Response to Appendix E – Action point 27. Colne Valley

Project: Norwich to Tilbury Electricity Transmission Project (EN020027)

Interested Party: Caroline Homewood – Ford Street, Aldham and Fordham in Colne Valley

Figure 4.3 Fordham and Fordstreet

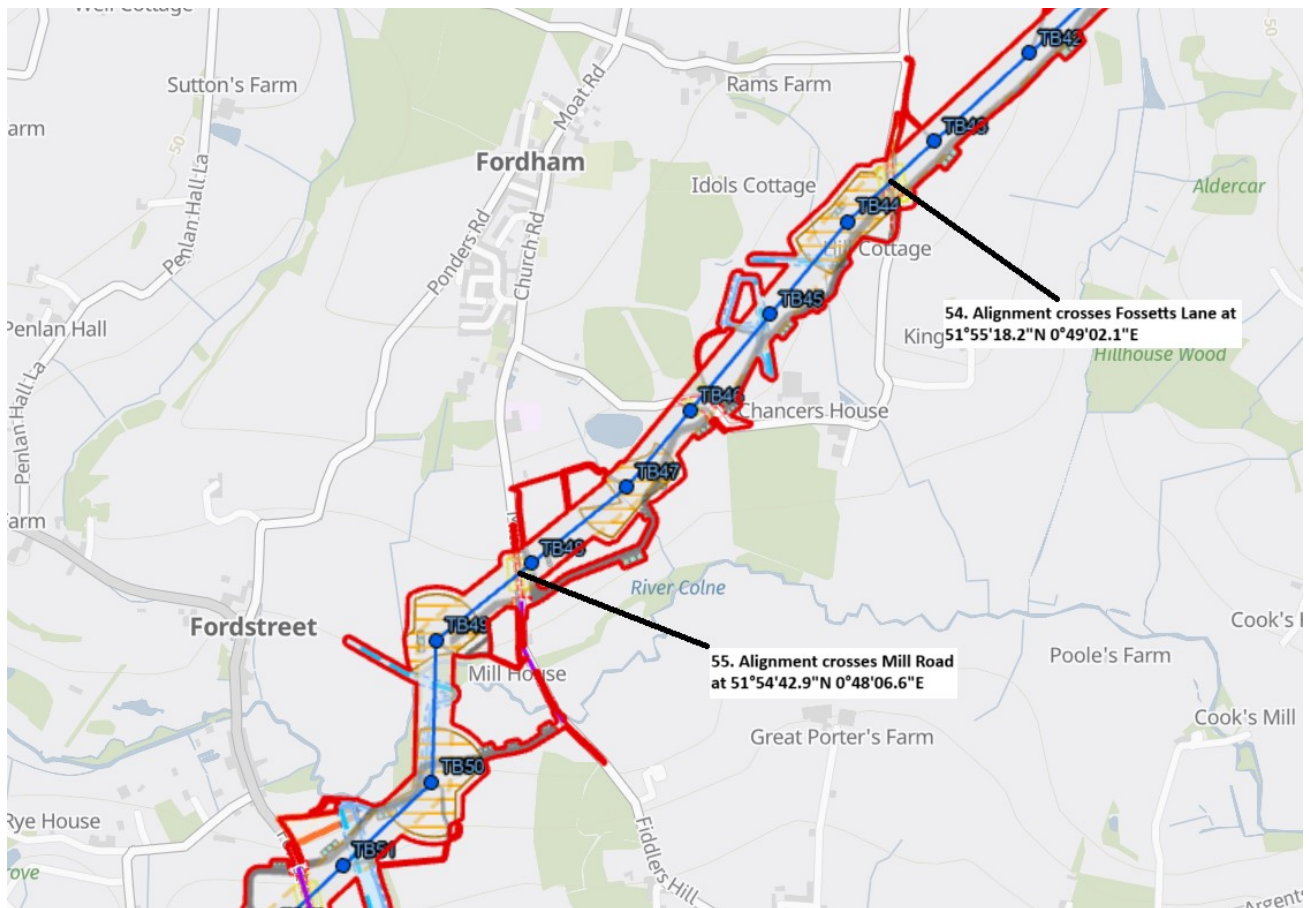
2. Pylons are located in open fields with little or no screening. The assertion that 50mt pylons and cables can be largely filtered or screened by 2 storey buildings and 2-3mt hedges is impossible. The sloping landform is gentle, which characterises the Colne Valley's special landscape. To state this will "largely filter or screen" pylons from Fordham Village and the Grade I listed Church is not possible or true.

3. To suggest that views towards the Project from within the Ford Street conservation area are filtered in places by intervening buildings, landform and vegetation is absurd. National Grid is placing pylons on high points of the valley to exacerbate harm to the Ford Street conservation area. The location of Pylon TB48 is approximately 30mts higher than the Ford Street conservation area, so increasing the pylon height to 80mts. TB49 is in an open field and located on a slope (approximately 15mts) higher than Ford Street behind hedge that is approximately 4mts high. TB51 is also situated 40mts higher than Ford Street. The run of pylons are located in elevated positions that will loom over and encircle the Ford Street conservation area. The claims made by National Grid about the Project being filtered by intervening buildings, landform

and vegetation is not possible or true.

5. Not true. Most of the land on which the run of pylons from TB45 to TB52 is land that is open to the public and forms part of the Fordham Hall Estate, not just the routes shown. Most of the land is open grazing land with hedges and some trees but no trees anywhere near the height necessary to offer genuine filtering from pylons and cables.

TB48 is right by the roadside some 35mts above the Ford Street conservation area and next to the Roman archaeological villa. TB51 and TB52 are at the top of valley located either side of the A1124 the main road into the Ford Street conservation area. At present, the drive into the Ford Street conservation is beautiful, from the high point of the valley (shown numbered 6 on the map) you have open views of the Colne Valley and then drop 40mts into the Ford Street conservation area. The map clearly shows the high concentration of listed buildings in the village. Pylons TB51 and TB52 and the associated cables will become the gateway into the Ford Street conservation area

Figure 4.4 Aldham

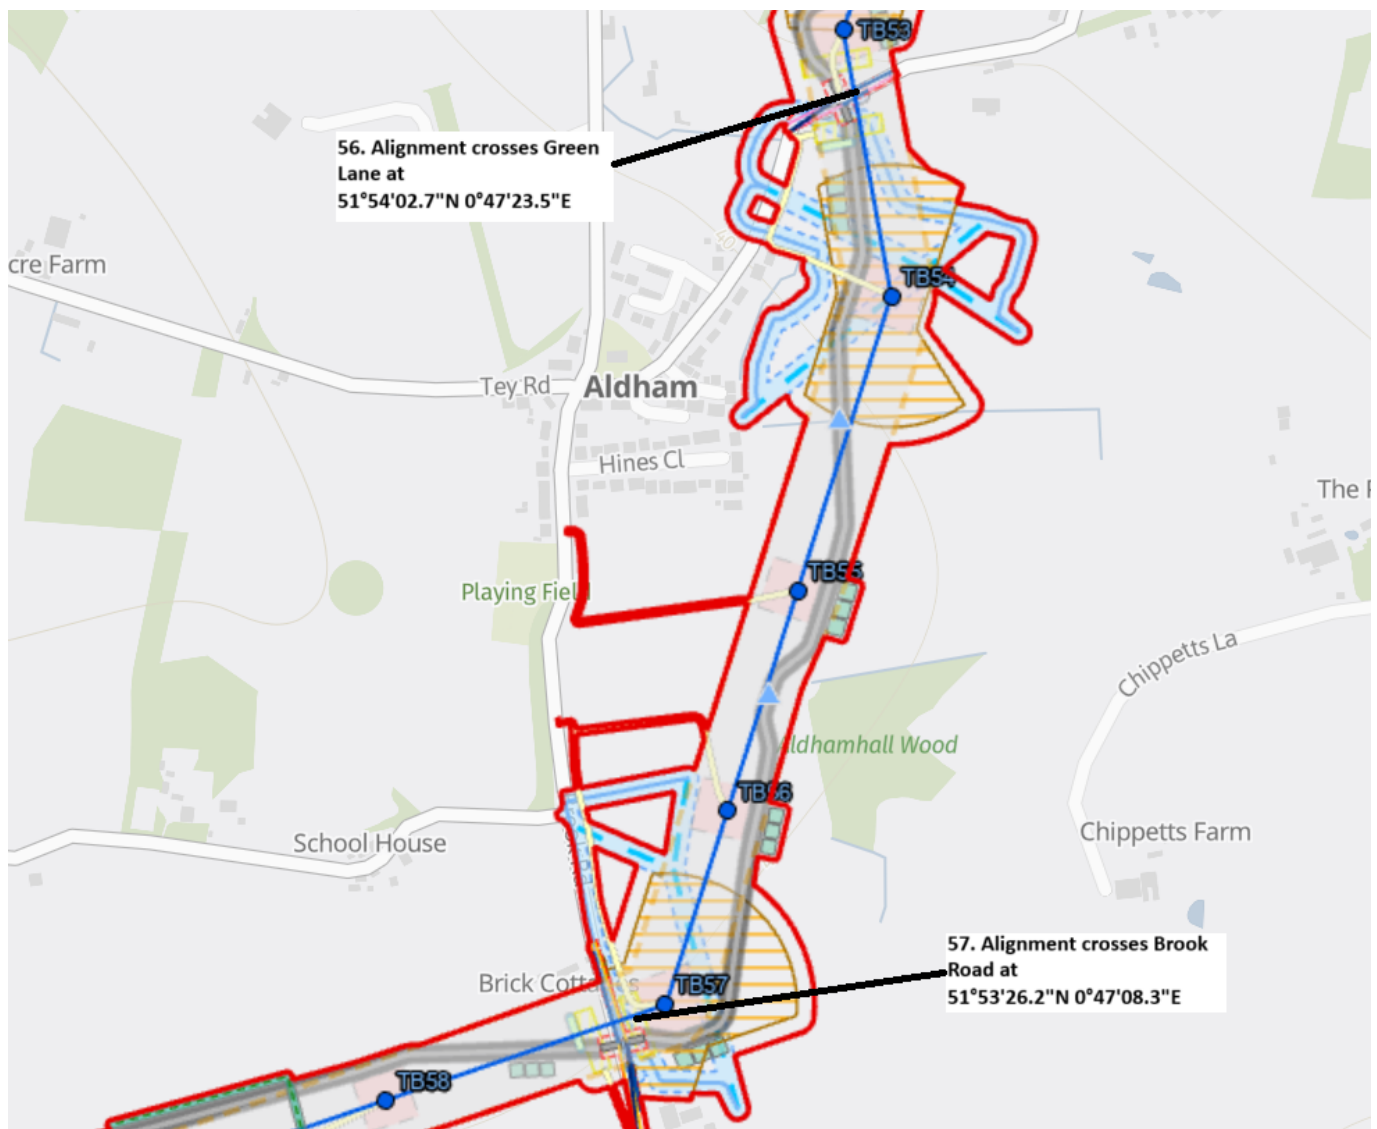
11. Not true. No trees in the Woodland Trust managed estate will obscure the pylons. It is derisory to put this forward as a solution. Even if a small part of the bottom of the pylon is obscured all the cables running between the pylons will to be visible. No buildings, landform or vegetation will obscure the cables which will strewn diagonally across the Colne Valley from Fordham, via the Ford Street conservation area and onto Aldham.
